Case Officer: Gemma Magnuson

Applicant: Mr & Mrs A Pasteur

Proposal: Discharge condition 6 (pipework and ventilation) of 19/00532/LB

2018-1014-GA02 **SERVICE MARKUP**

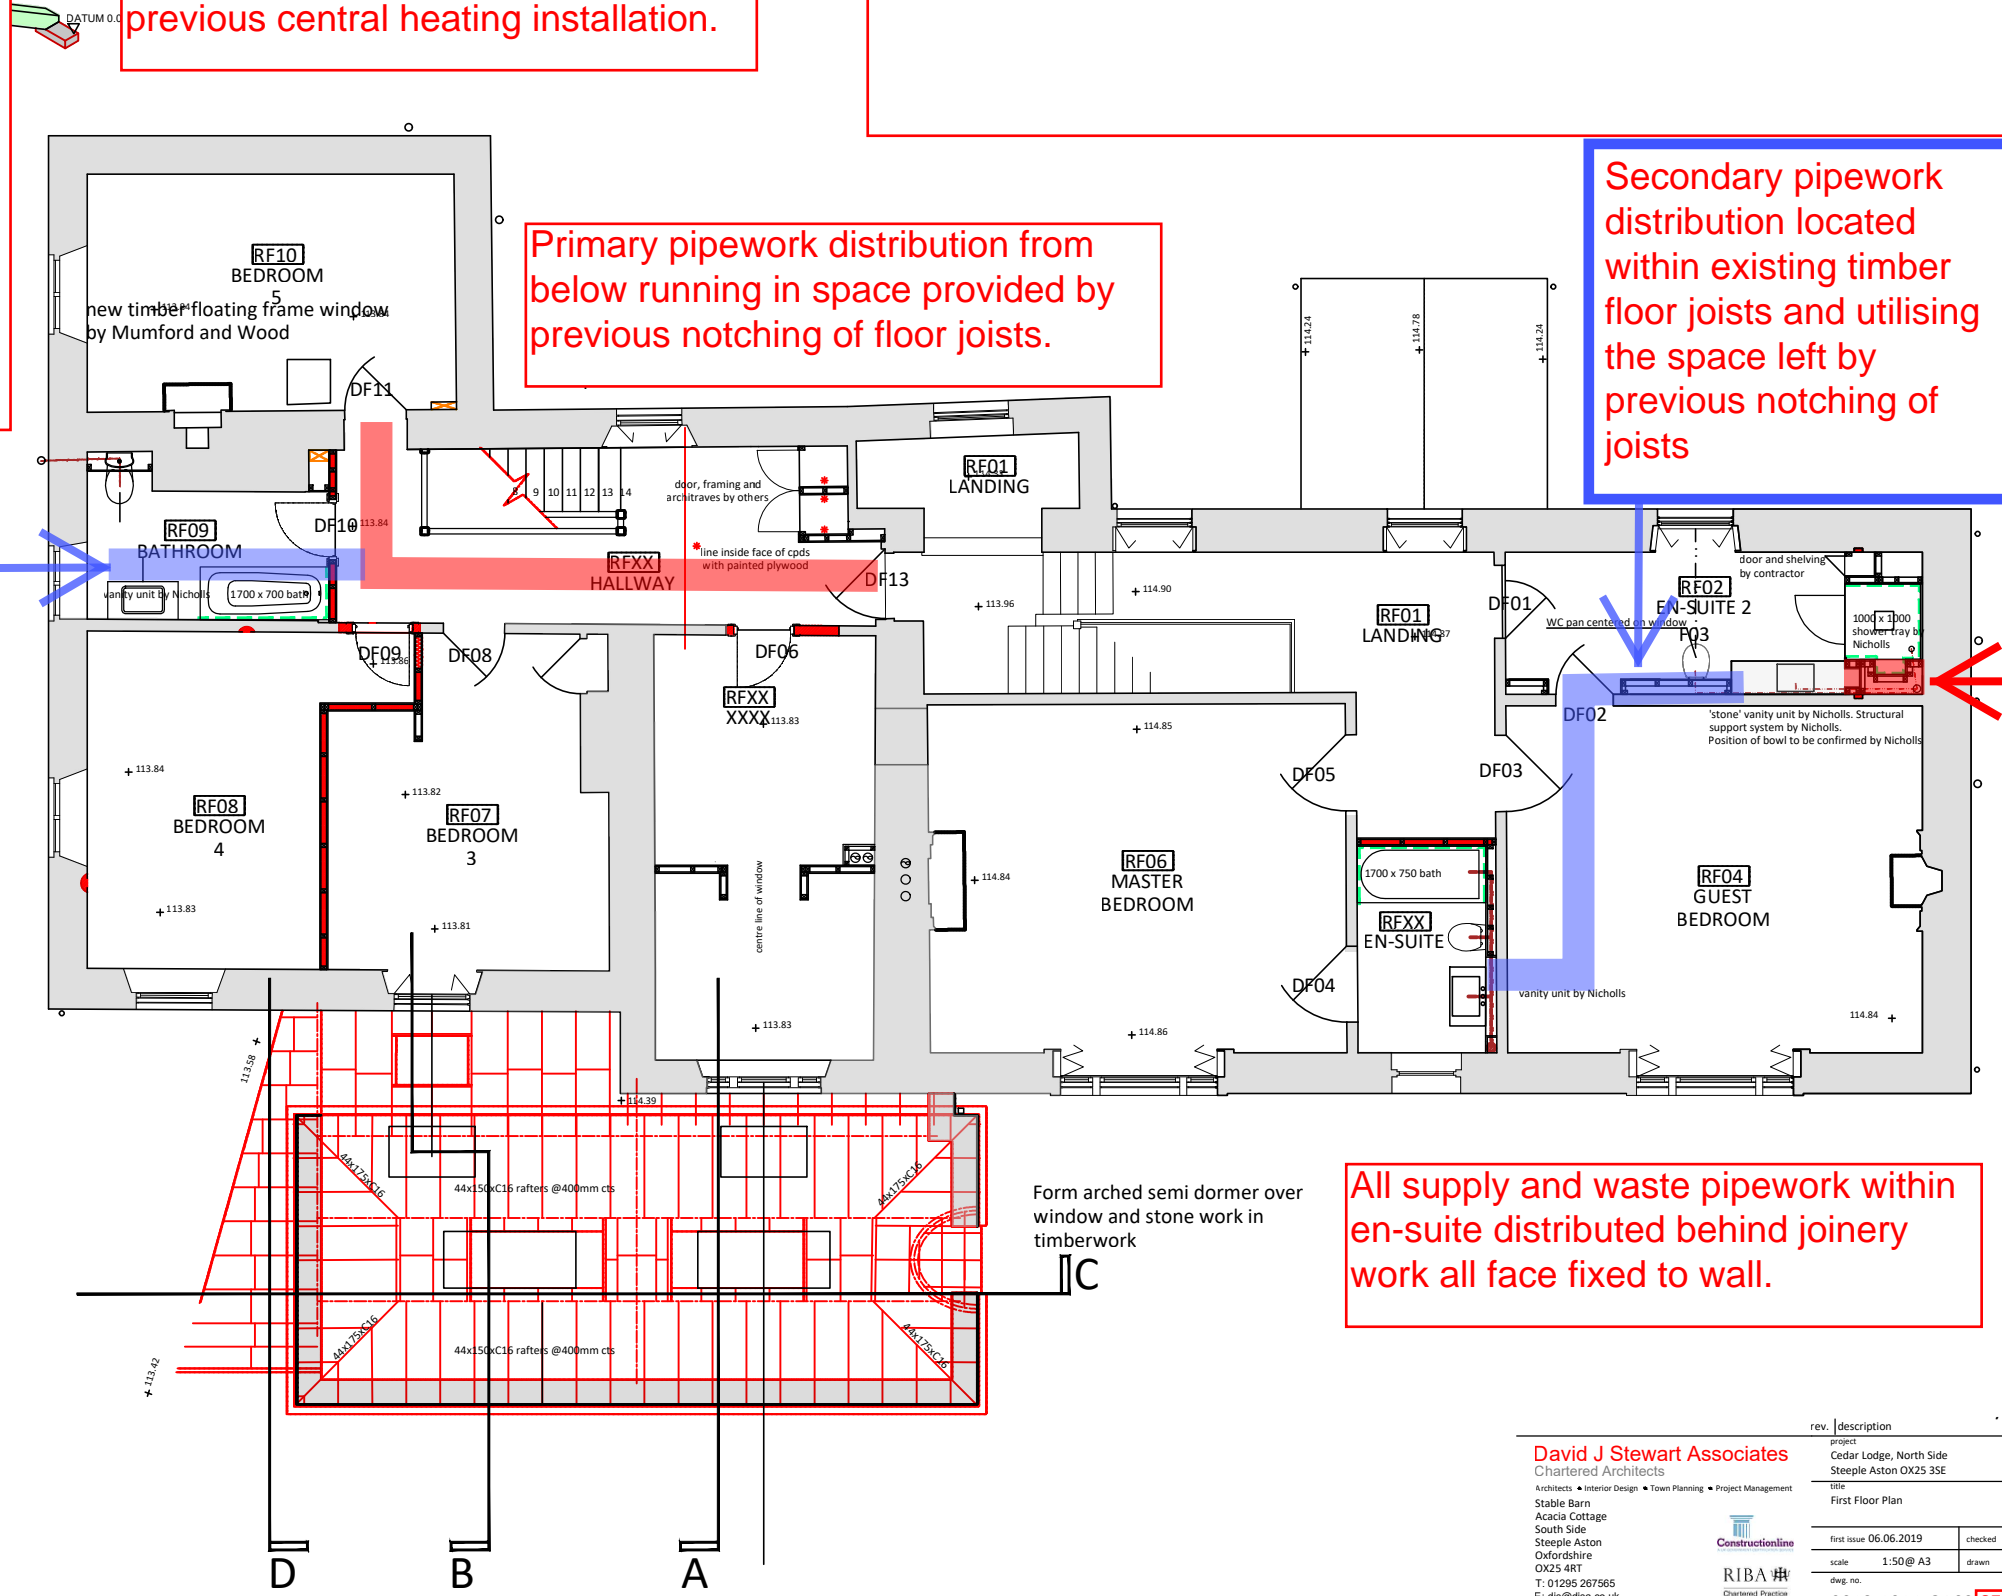
- 5.1. CDC Conservation - The plans appear to indicate that the new plumbing will be set within newly constructed joinery and will not impact on historic fabric. The soil and vent pipe is to be brought down through the existing floor on the interior of the building and will not breach through the rear wall of the building. It is assumed that the existing window provides sufficient ventilation and that no additional ventilation is required. It may be useful to have a paragraph from the agent confirming this. There

would be no objections to the discharge of condition if the impact on historic fabric is limited to the insertion of the soil and vent pipe.

6.1. I see no reason to disagree with the assessment of the Conservation Officer that the details on the plans are acceptable. I therefore recommend that the condition is discharged.

Pipework and ventilation in accordance with Drawing No's: 2018-1014-GA01 and 2018-1014-GA02 received with the original application on 24 March 2020.
